A38 Derby Junctions
TR010022
8.15(b) Statement of Common Ground
with
McDonald's

**Statement of Common Ground
McDonald's**

| Version | Date | Status of Version |
|----------------|--------------|--------------------------|
| Final | 18 June 2020 | Deadline 14 Submission |

DELIVERY TRACKS

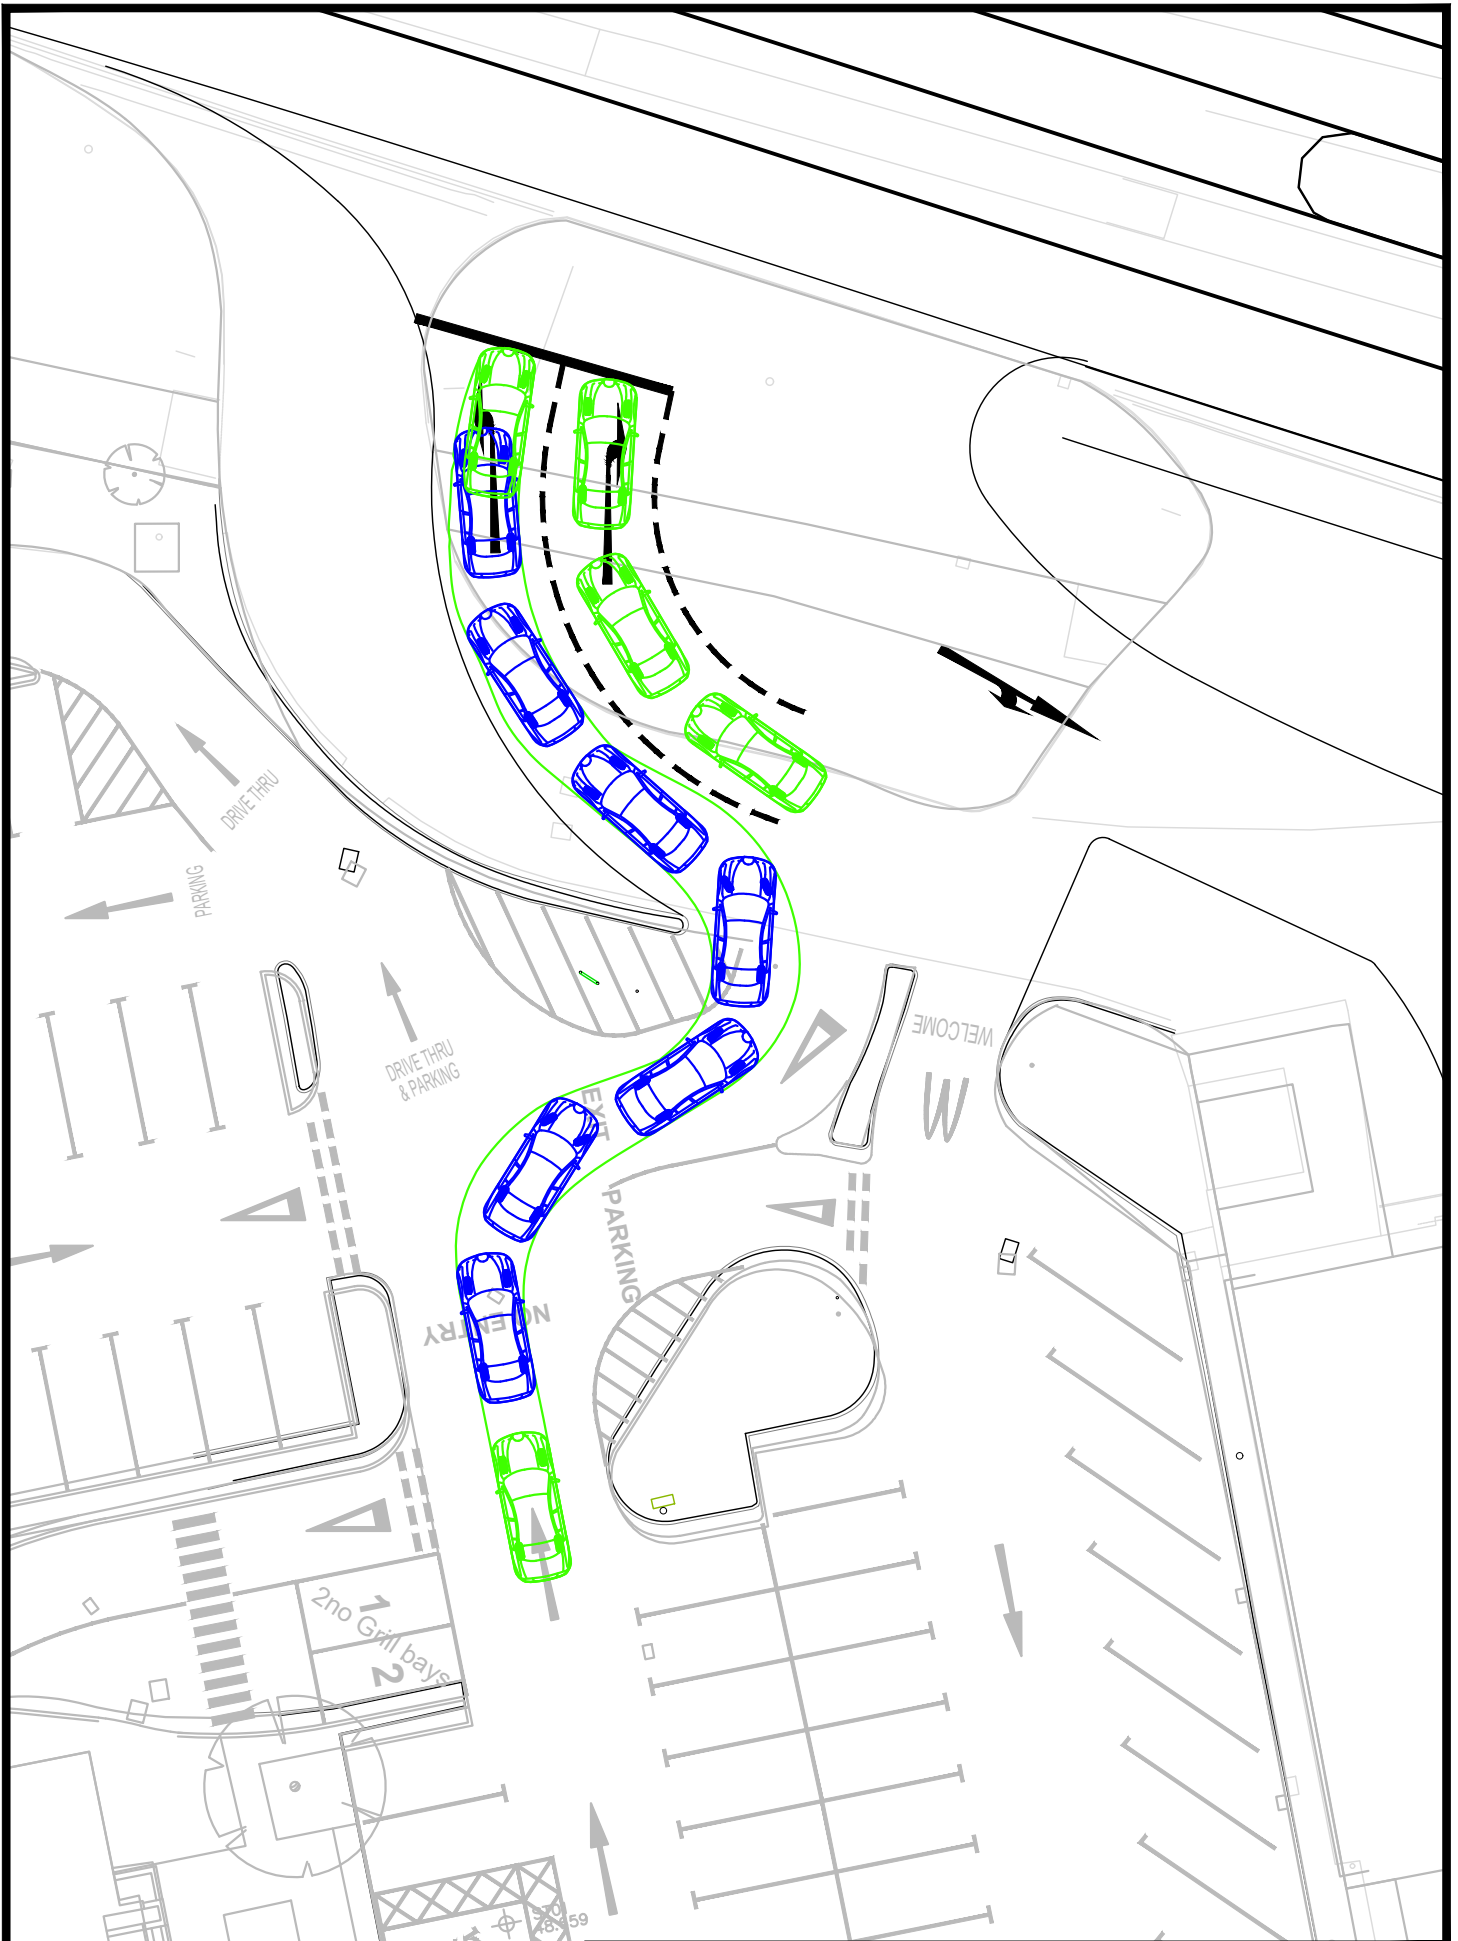
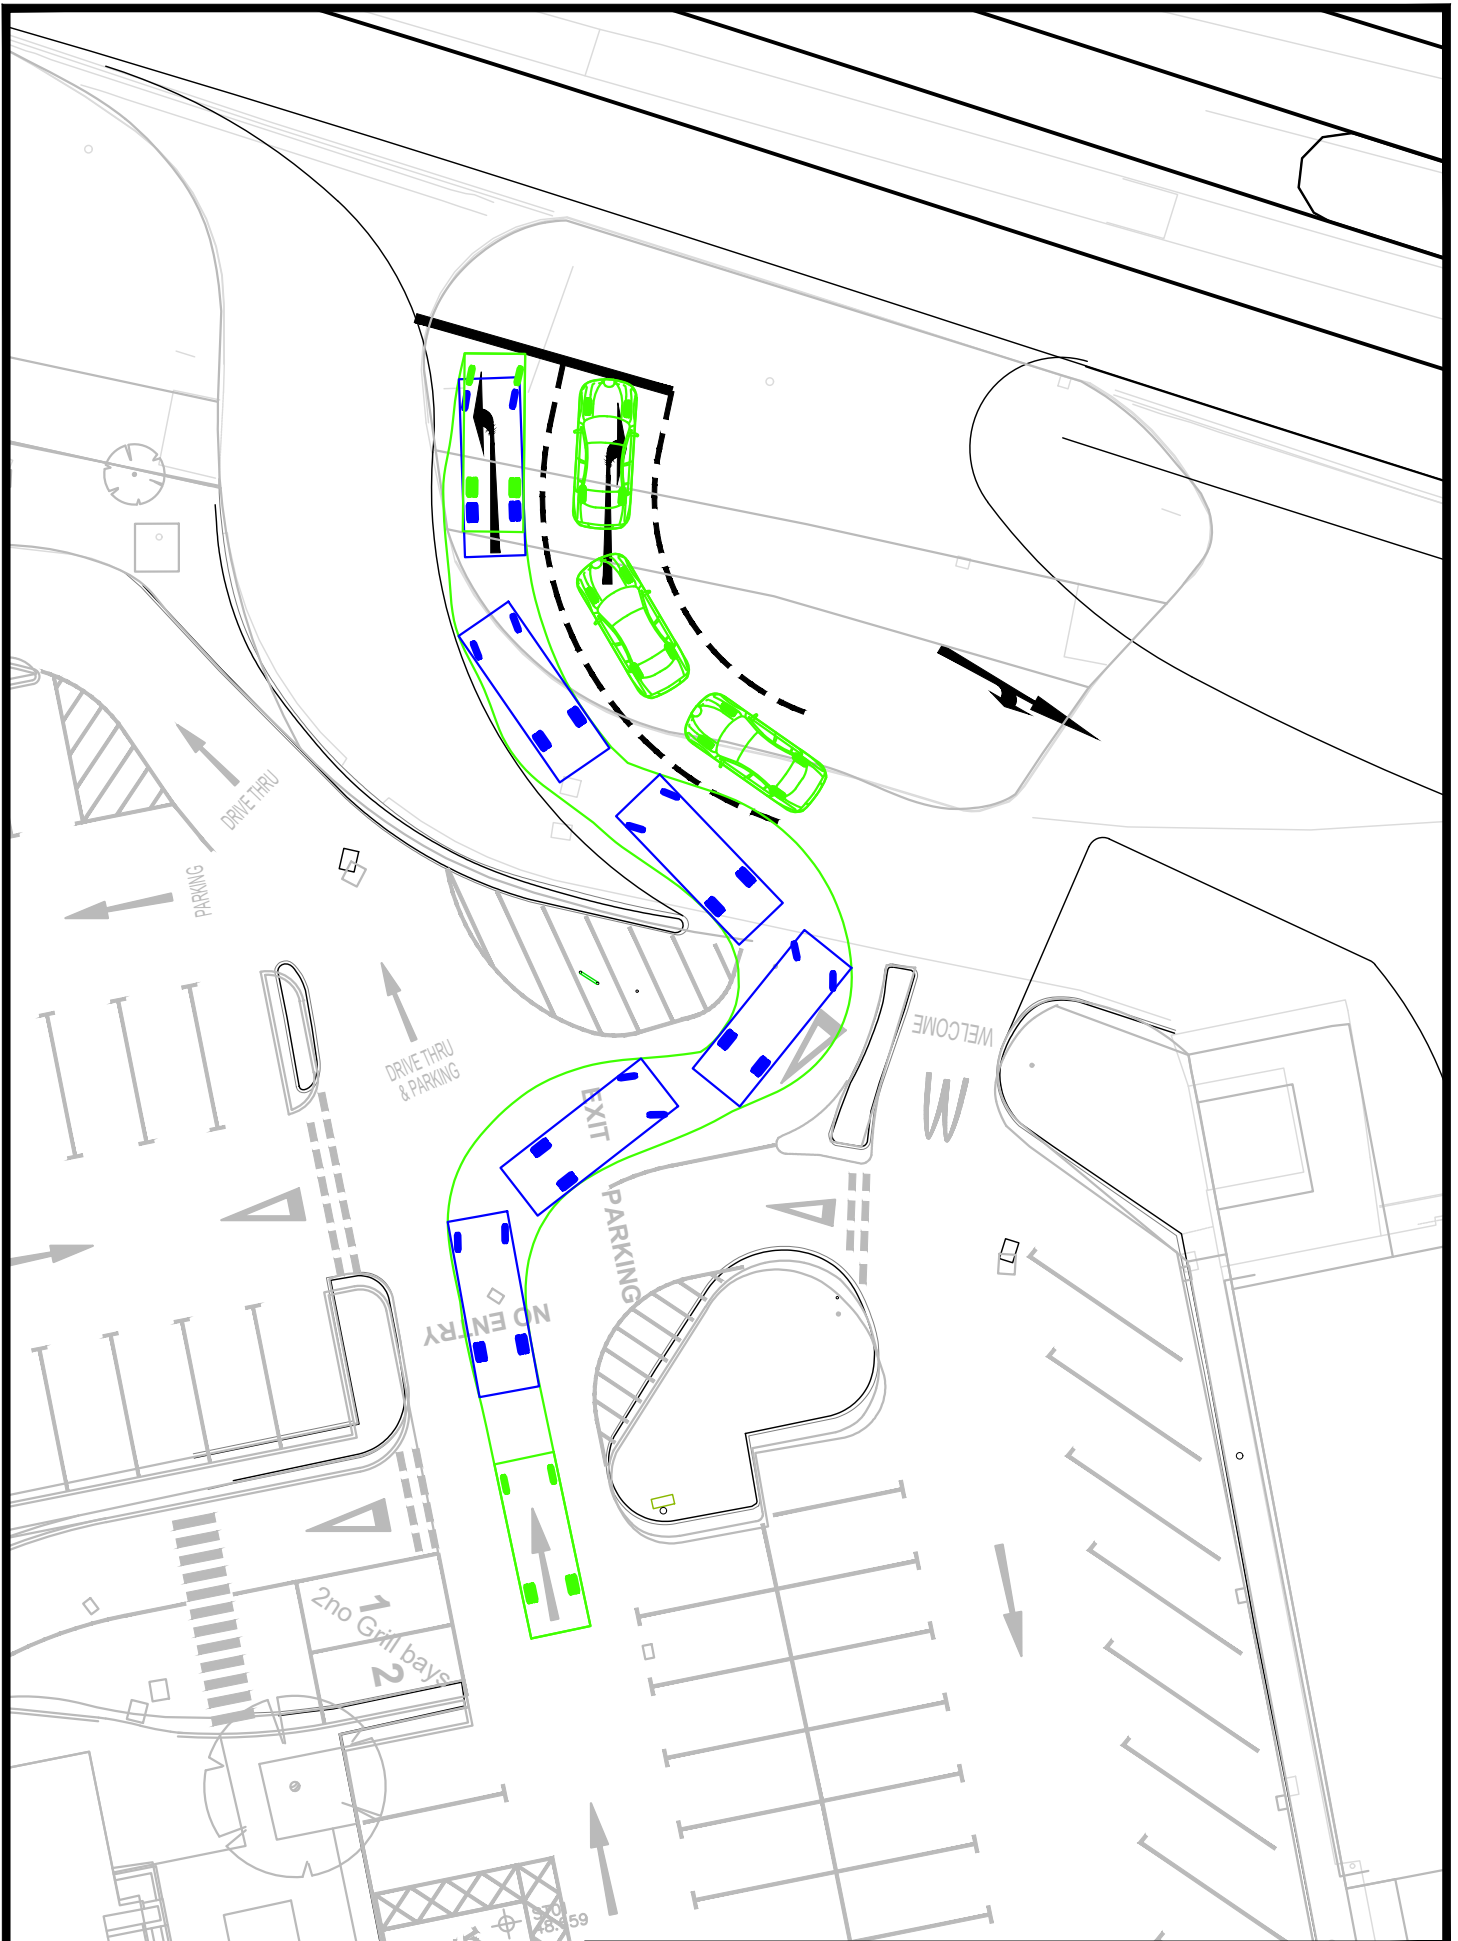
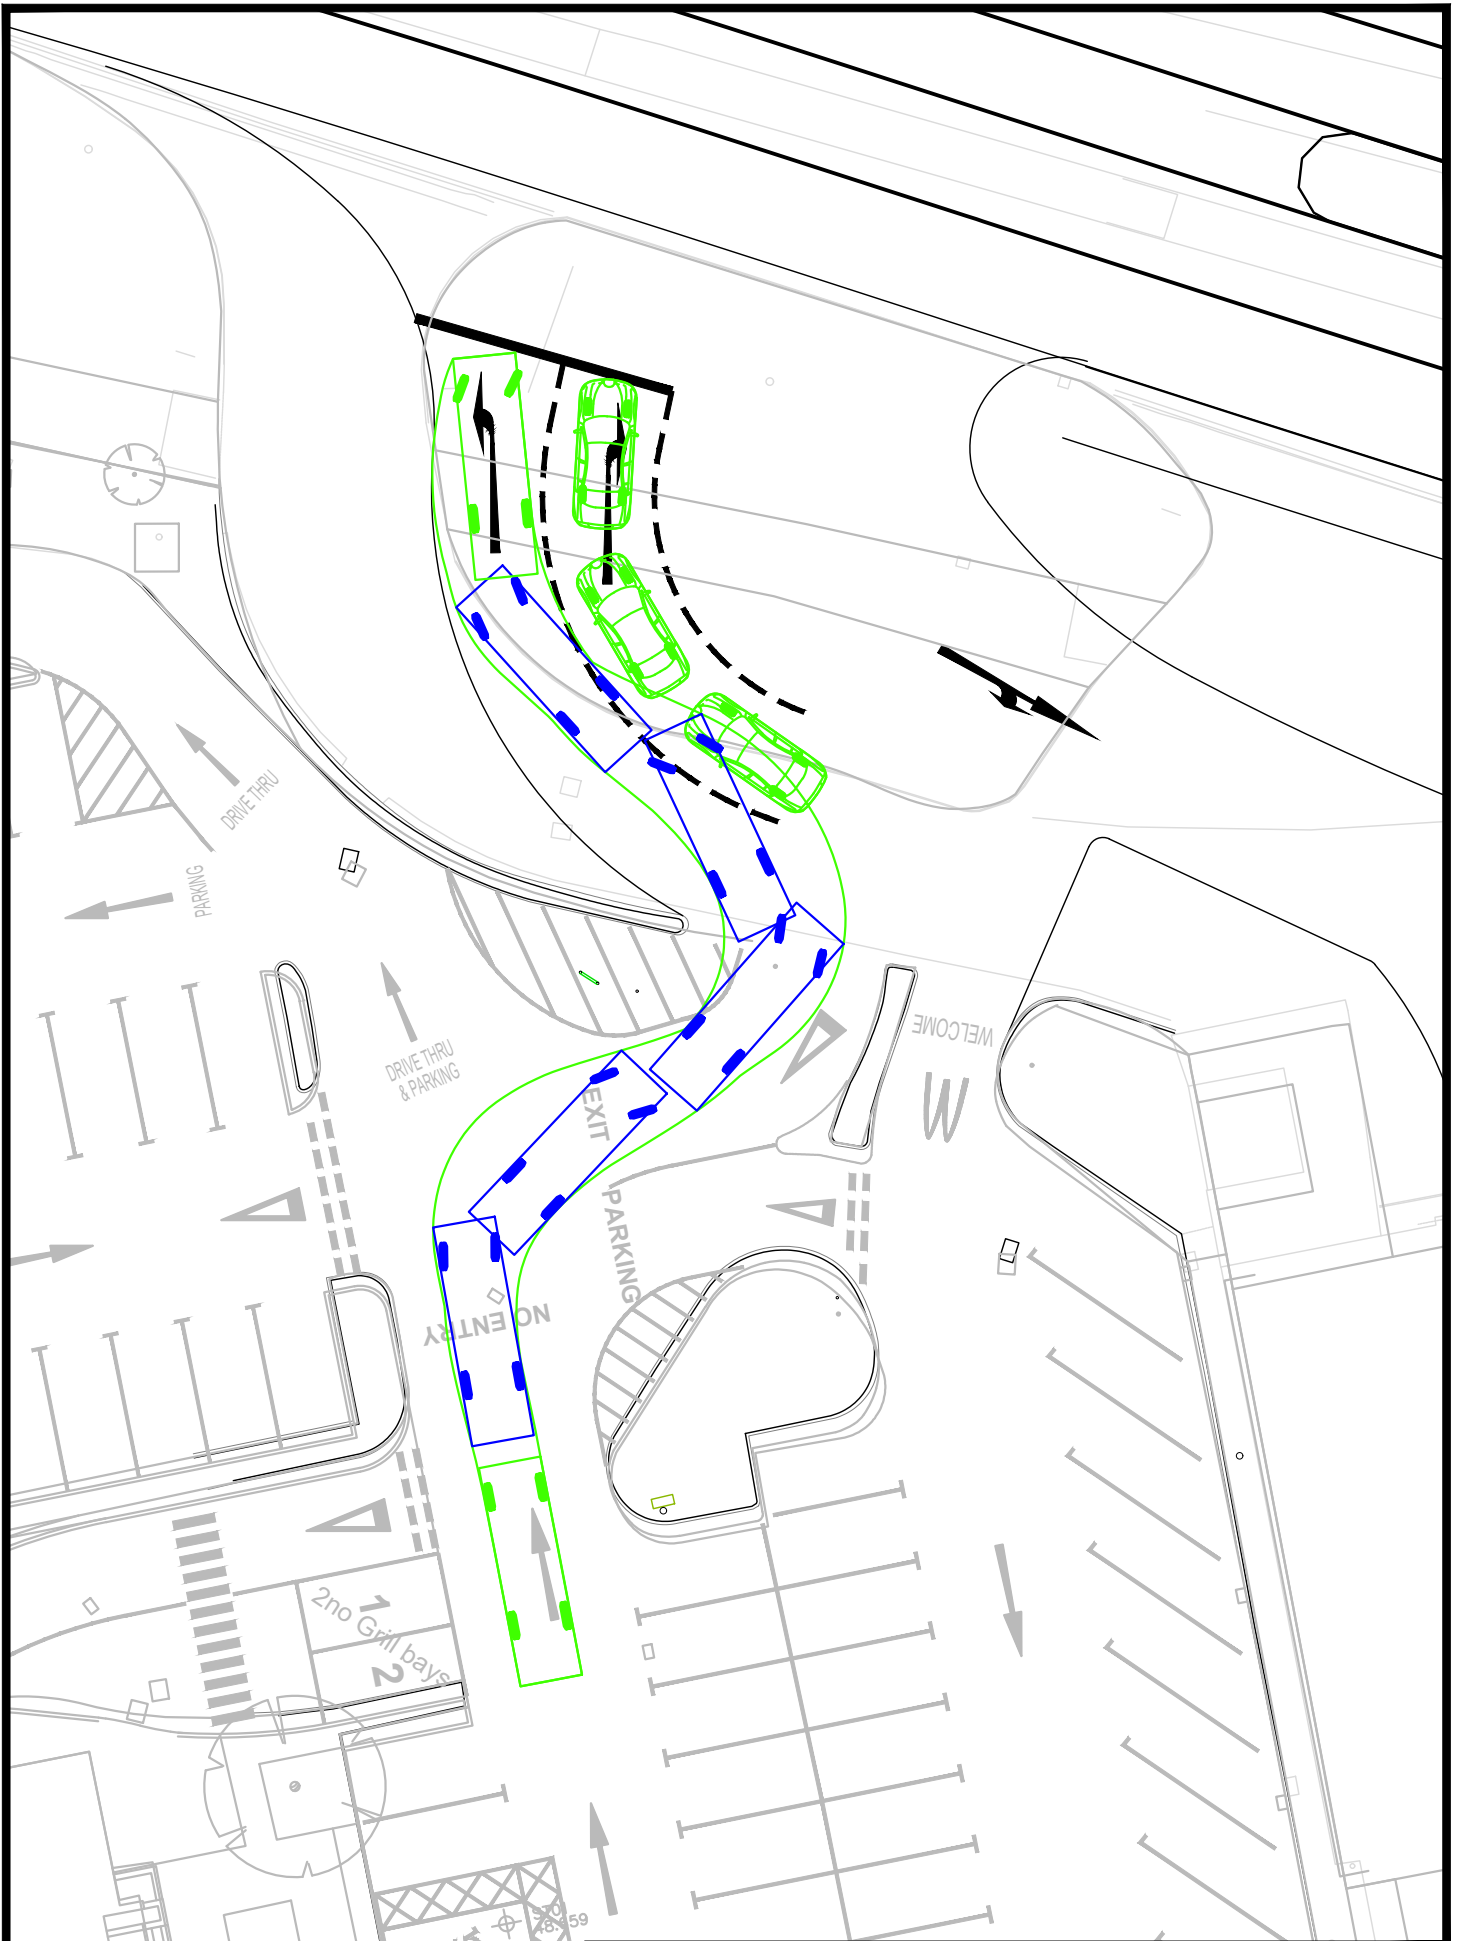
| Issues Reference (see Appendix A) | Document | Paragraph Ref | Sub-section | Comment | Highways England Response | Status |
|--|----------------------------------|---------------|-------------|--|---|------------------|
| Issue ref: I.1, access and potential impacts | Written Representation Comments* | Point 2 | a) | <p>Currently, deliveries to the Property are received five times per week from the A38 entrance. The Works necessitate a change in delivery routes into the restaurant. The proposed route does not account for how McDonald's delivery vehicles manoeuvre around the Property or potential health and safety concerns. Delivery cages weigh hundreds of kilograms and McDonald's car park is reinforced in the south part only. By closing the A38 entrance, delivery vehicles will no longer be able to service the Property; they are too heavy to safely cross the unreinforced north section of the Property.</p> | <p>Swept path diagrams have been provided to demonstrate that access for deliveries from the proposed new A52 access is feasible within the current car park layout (and crossing onto the Euro Garages land as they do at present).</p> <p>Highways England has advised that, during the detailed design stage, pavement surveys could be carried out to determine the strength of all parts of the car park – strengthening could be carried out as accommodation works if required.</p> <p>Highways England would welcome details of the existing car park construction (strengthened area and non-strengthened area) if available to be able to assess the load bearing capability.</p> <p>At the meeting on the 15th of January 2020, McDonald's noted that they have committed to taking core samples in</p> | Under discussion |

| Issues Reference (see Appendix A) | Document | Paragraph Ref | Sub-section | Comment | Highways England Response | Status |
|-----------------------------------|----------------------------------|---------------|-------------|--|--|--------|
| Issue ref: I.1, access and safety | Written Representation Comments* | Point 2 | b) | Servicing via Enfield Road (if this remains open) is not appropriate since it is unsafe for heavy trolleys to pass across a non-flat route. There are also practical concerns relating to the safe operation of large commercial vehicles. | It will not be necessary to consider routing deliveries via Enfield road if the above proposals are accepted. | Agreed |
